plat review2 responses.pdf Markup Summary

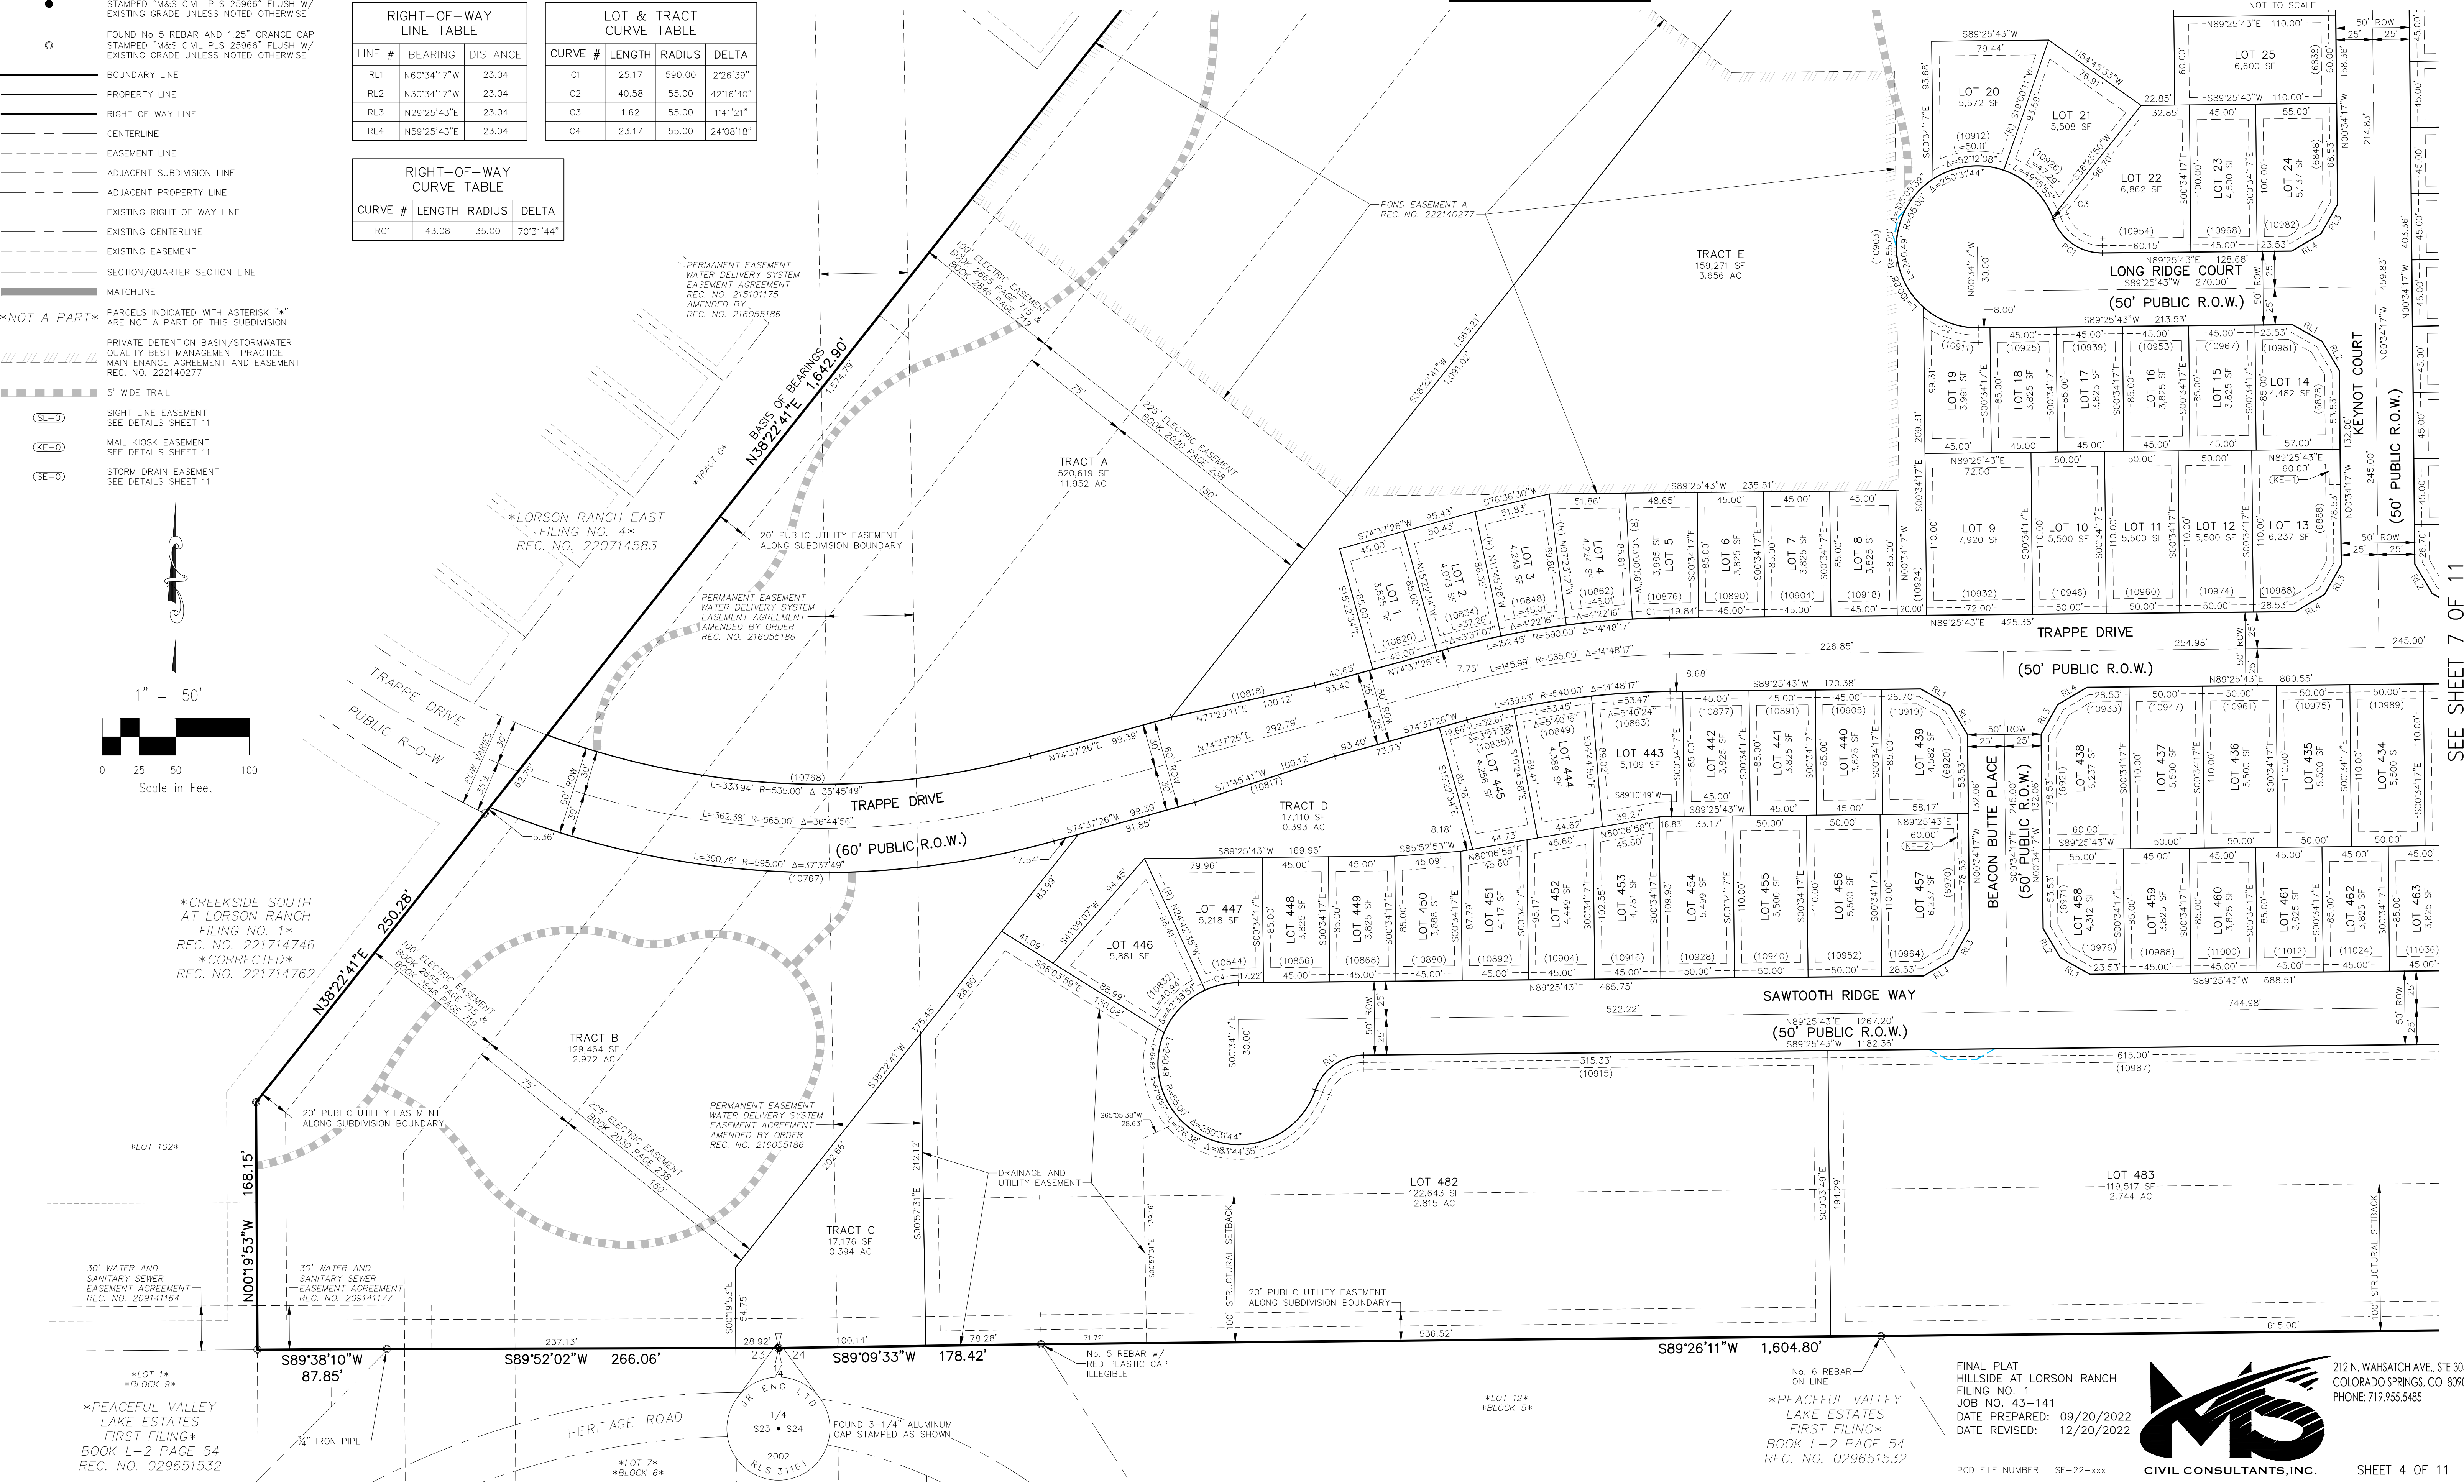
Provide / label public improvements easement

Labeling for additional public improvements easement added.
